From: Giacomelli, Alison (NE) [REDACTED]
Sent: 03 July 2018 17:01
To: Planning.Responses
Subject: NE Response re: P/60/18/DOC Details for Condition 14 & 16 for P/76/16/PL - Sefter Farm, Pagham Road, Pagham PO21 3PX (Arun)

Our Ref: 249465
Your Ref: P/60/18/DOC

Thank you for consulting Natural England on the discharge of conditions 14 and 16 in relation to land at Sefter Farm, Pagham.

PROJECT
New Packhouse
Setter Farm, Pagham
Drainage General Arrangement (Sheet 1 of 2)

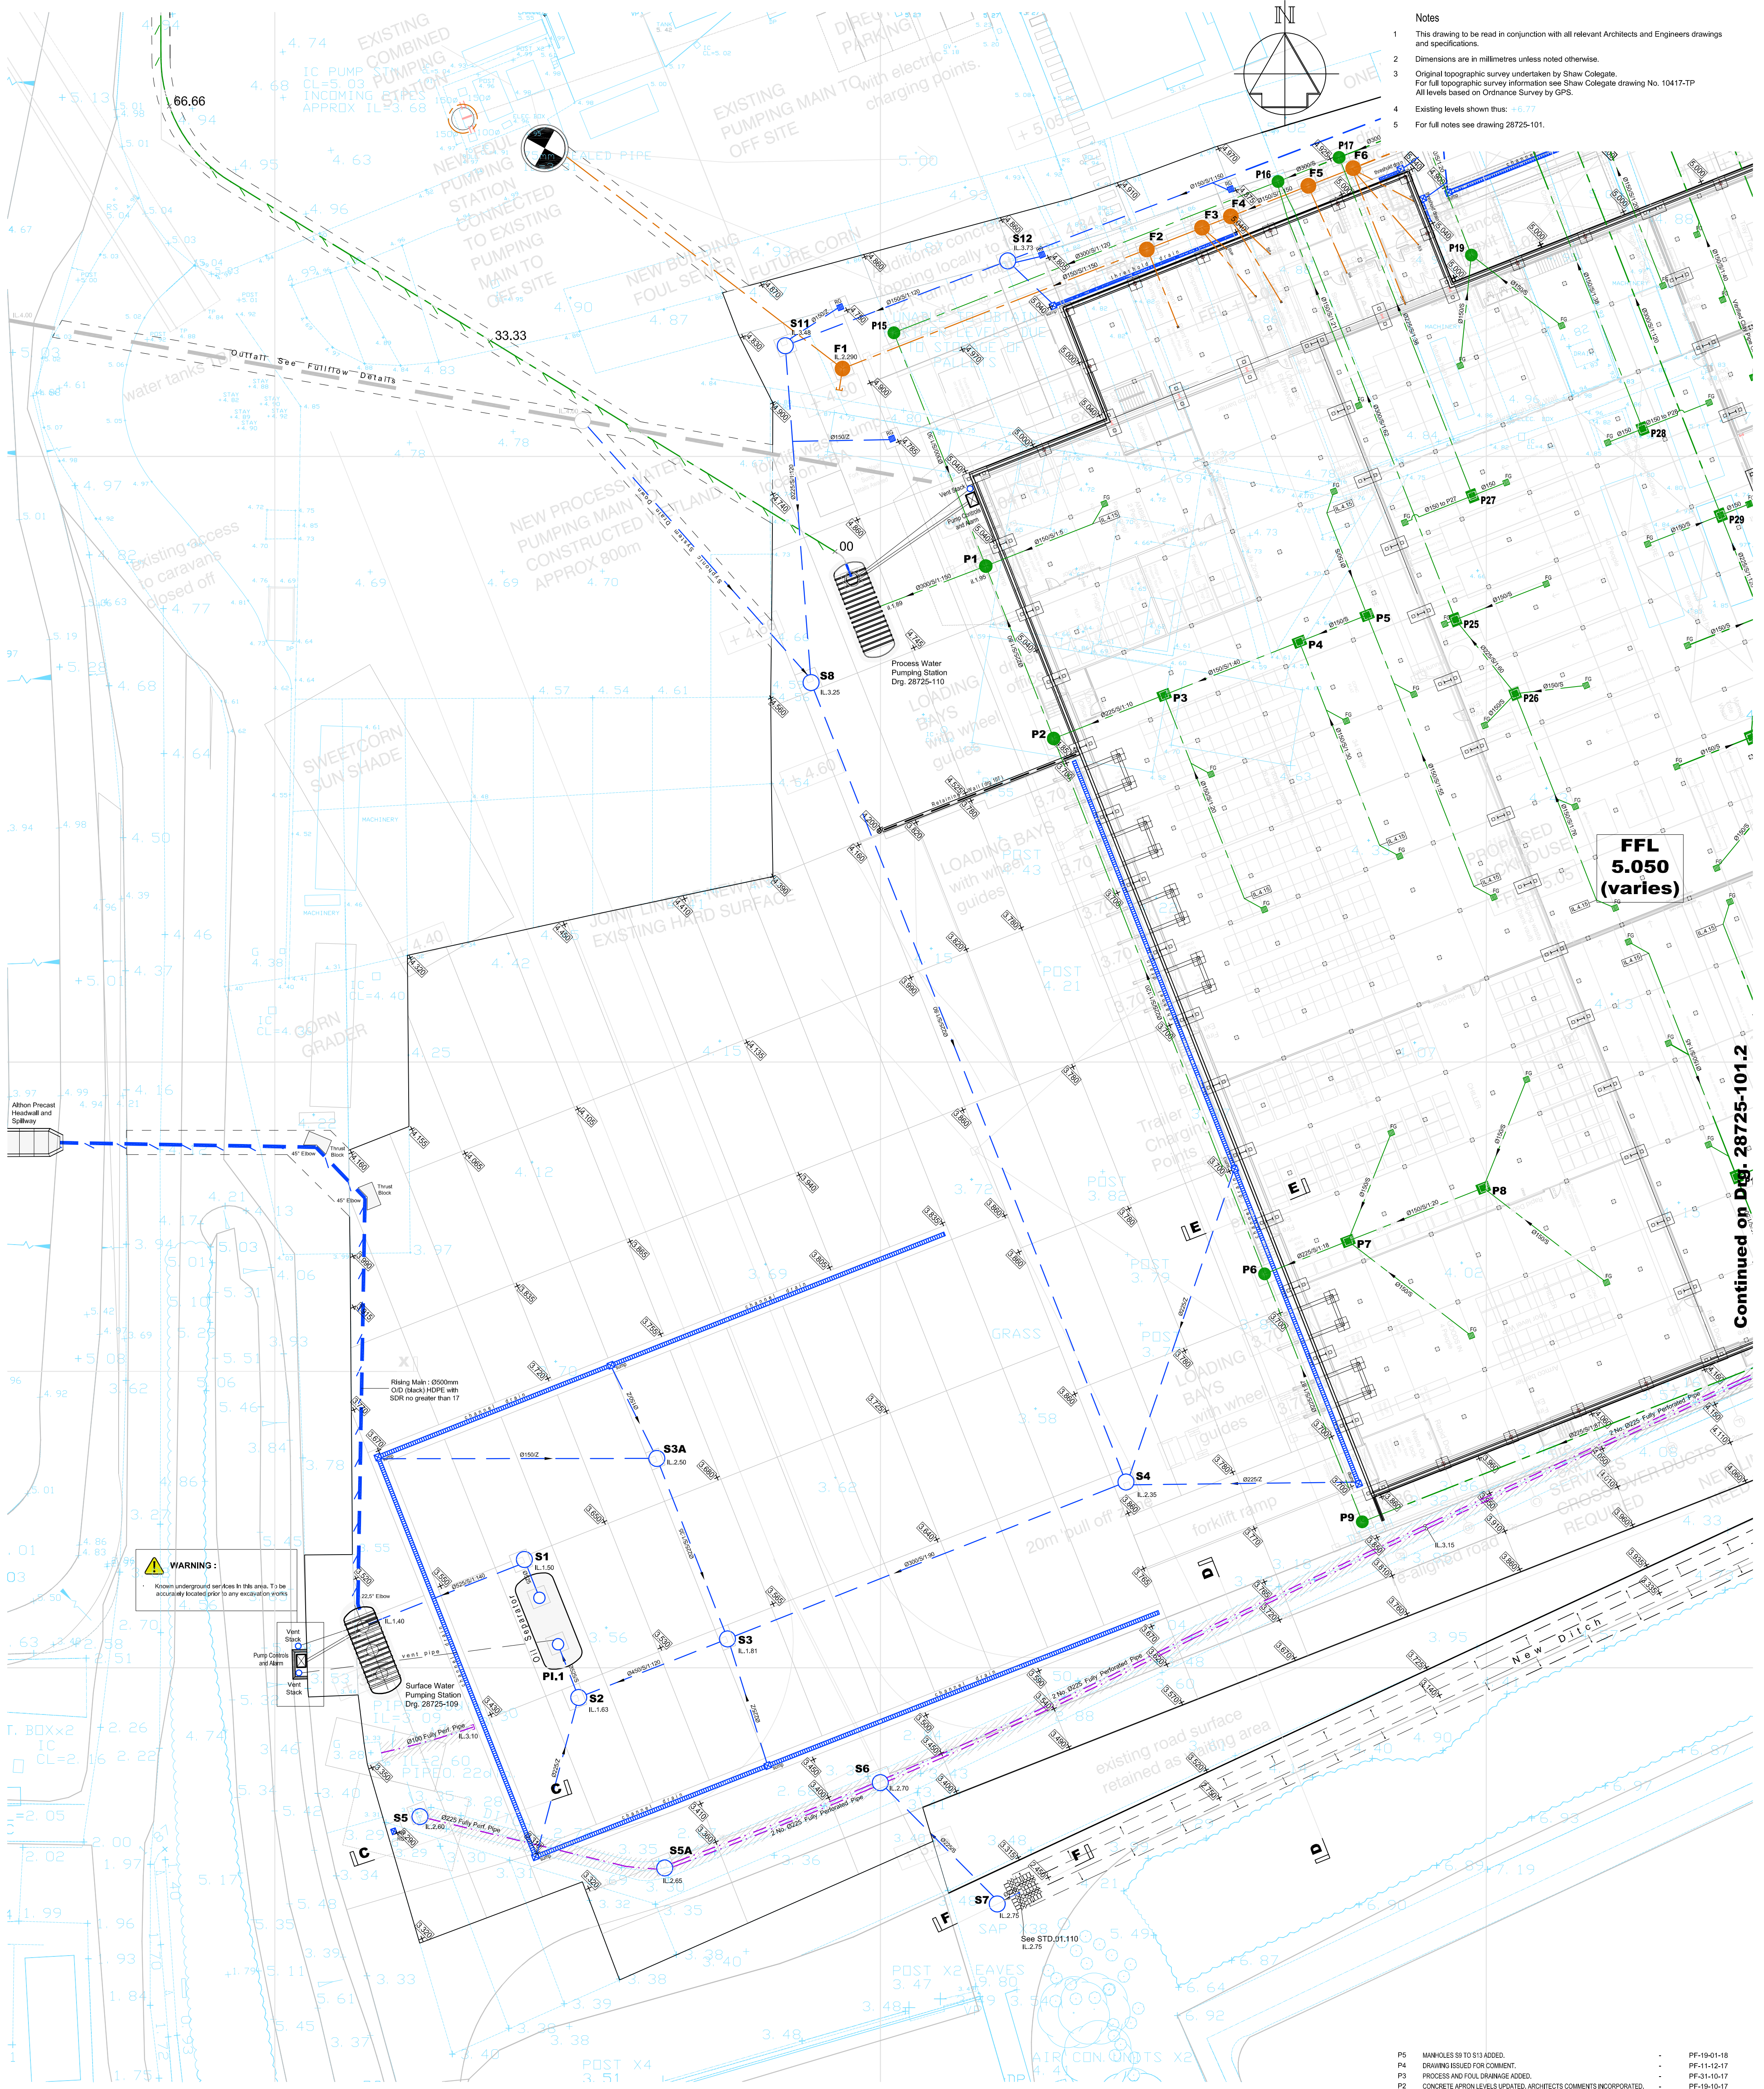
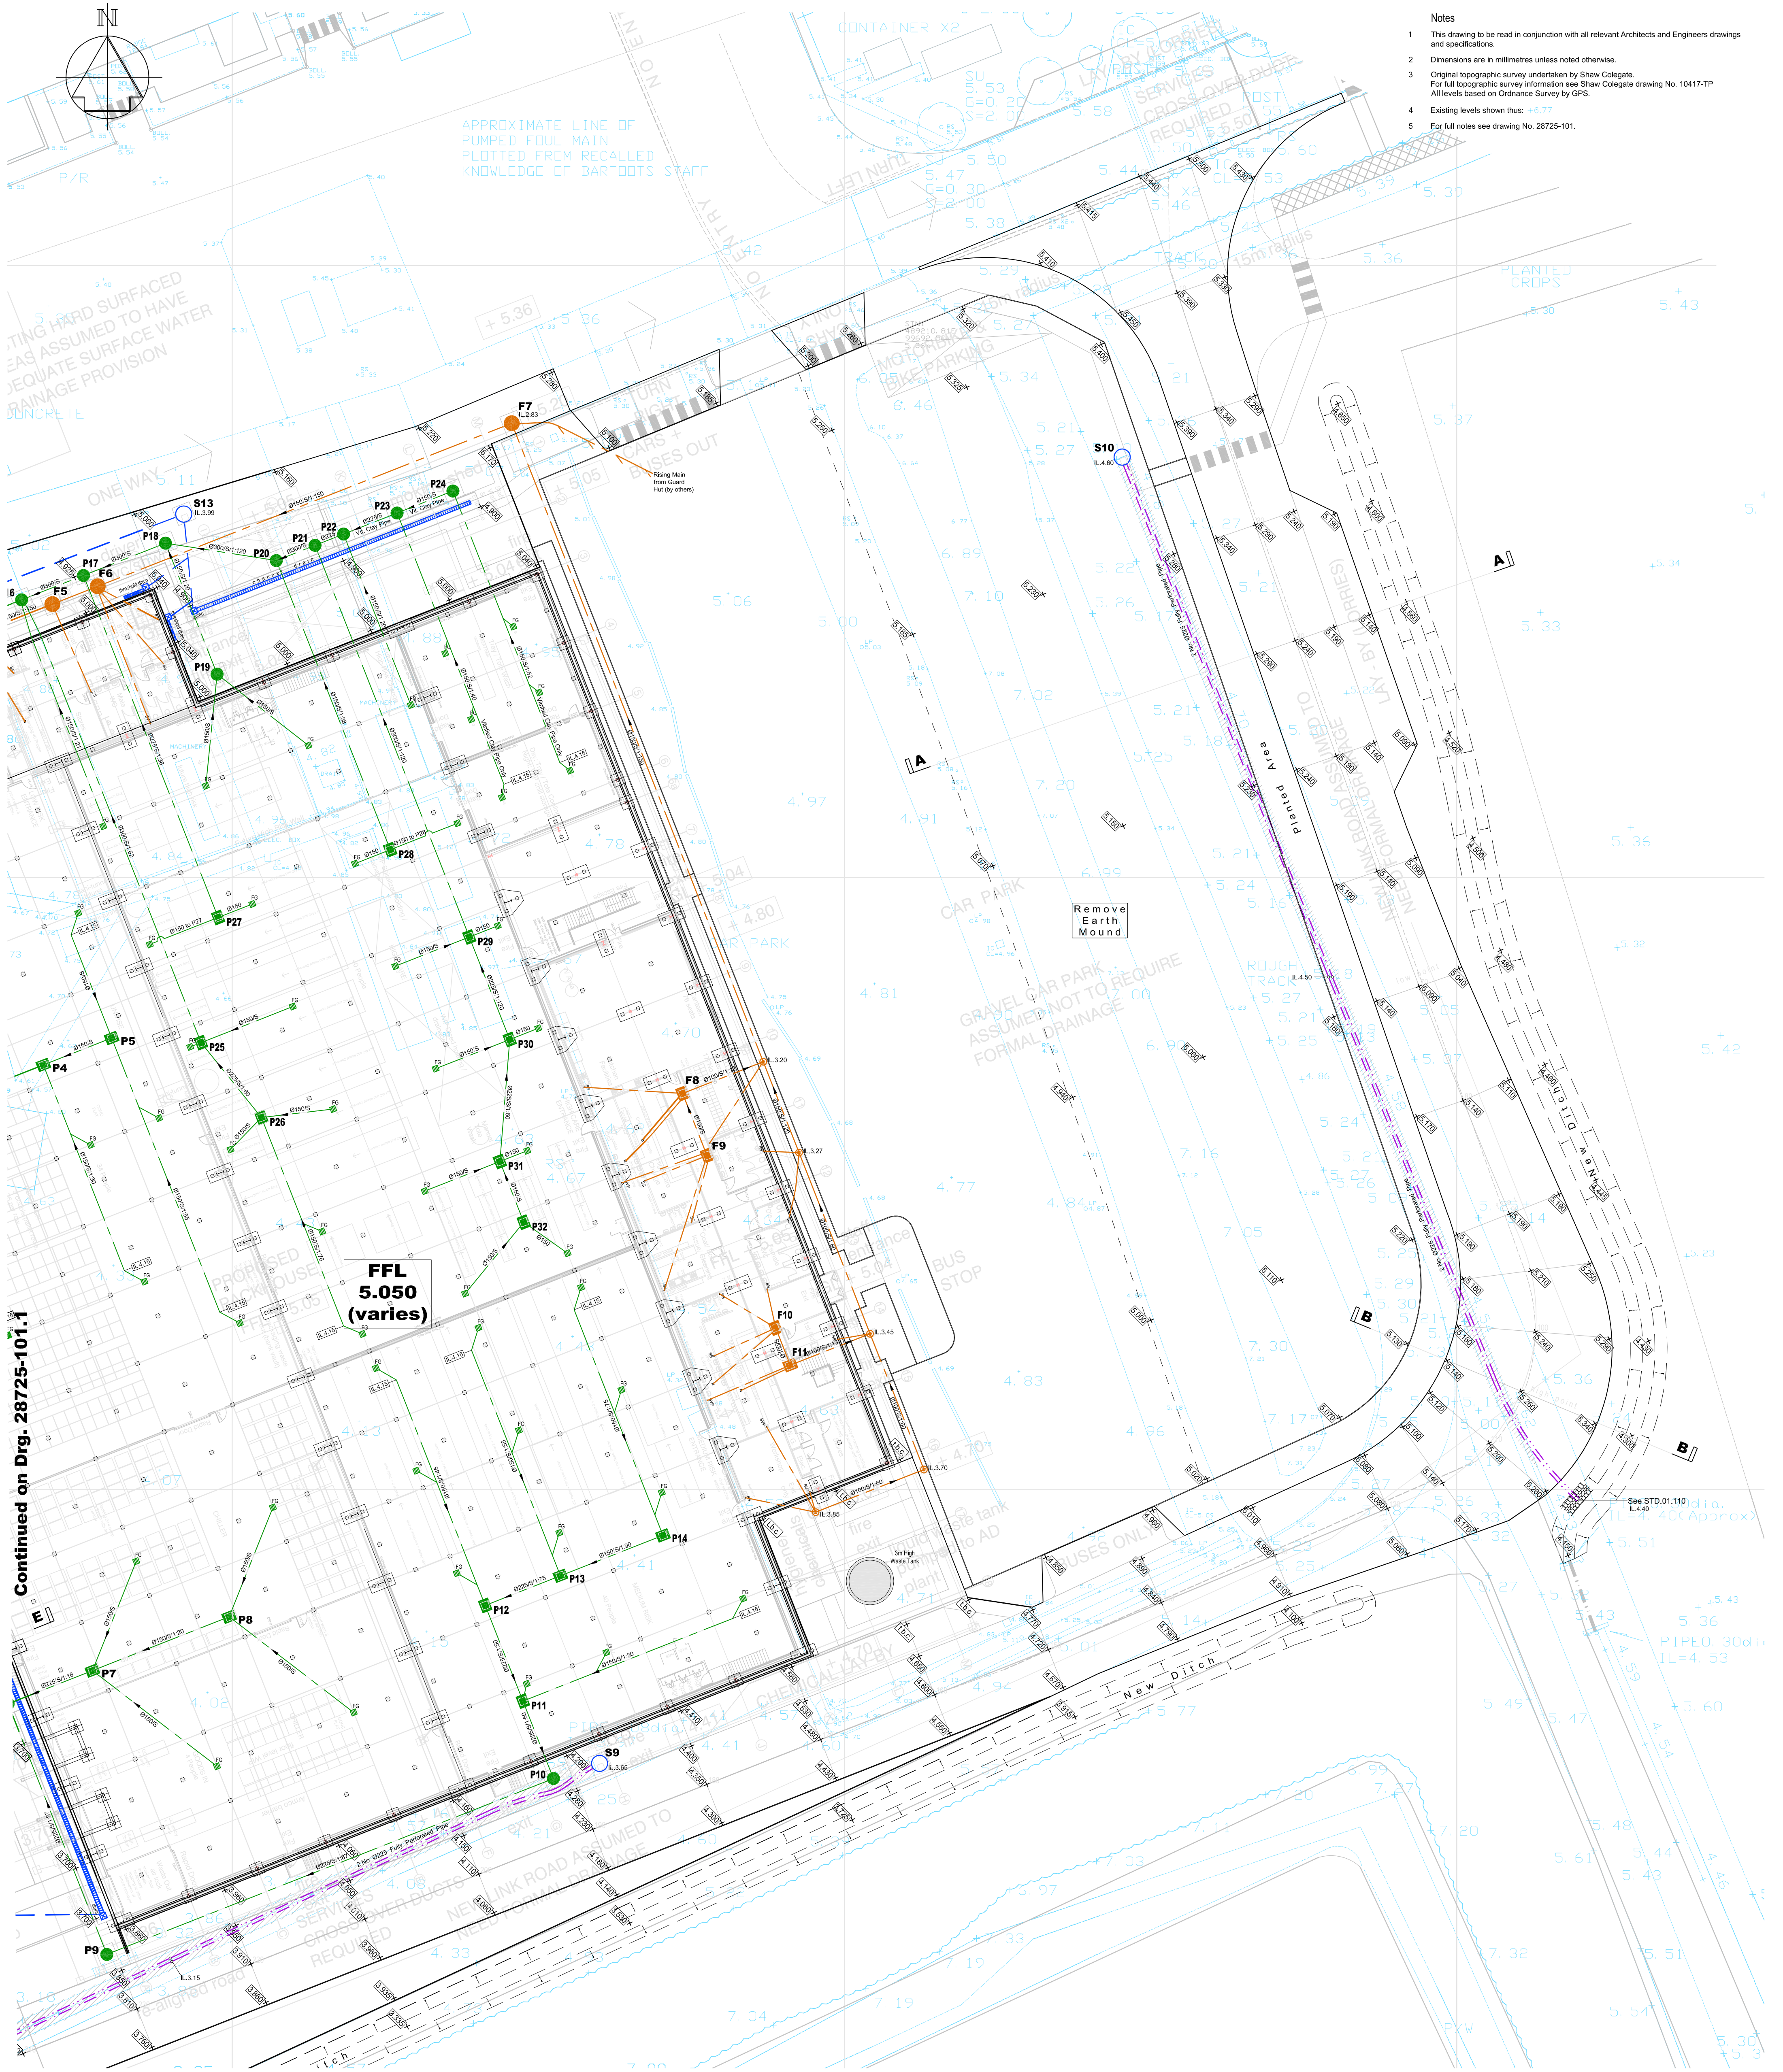
The submitted plans indicate that surface water run off will be directed into the reservoirs on site, and that this water will be used for the irrigation of fields. Collecting and re-using run-off in this way is beneficial as it reduces the need to abstract from Pagham Rife.
